**PRIVATE DETENTION BASIN /  
STORMWATER QUALITY BEST MANAGEMENT PRACTICE**

**MAINTENANCE AGREEMENT AND EASEMENT**

B. WHEREAS, Owner desires to develop on the Property industrial facilities to be known as Gleneagle Golf Course Residential Infill Development Fil. No. 2; and

EXHIBIT B
MAP OF THE PROPERTY SHOWING TRACT A AND THE LOCATION OF THE
DETENTION BASIN FOR FILING NO. 2

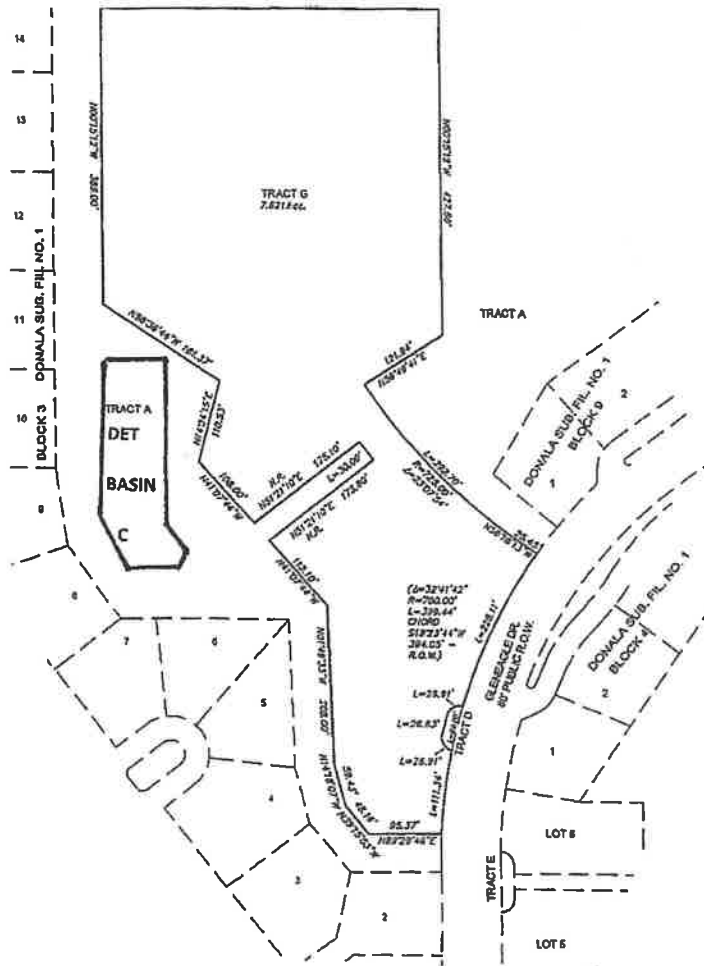
Please clarify who the parties are, that will be responsible for long term Maintenance of all areas, drainage swales tracts, easements, detention basin BMP's etc.

Doesn't the development agreement with Gleneagle Golf Course Residential Infill filing 1 required the HOA to take the open space and thus detention areas? HOA owns tracts now.  
Recitals
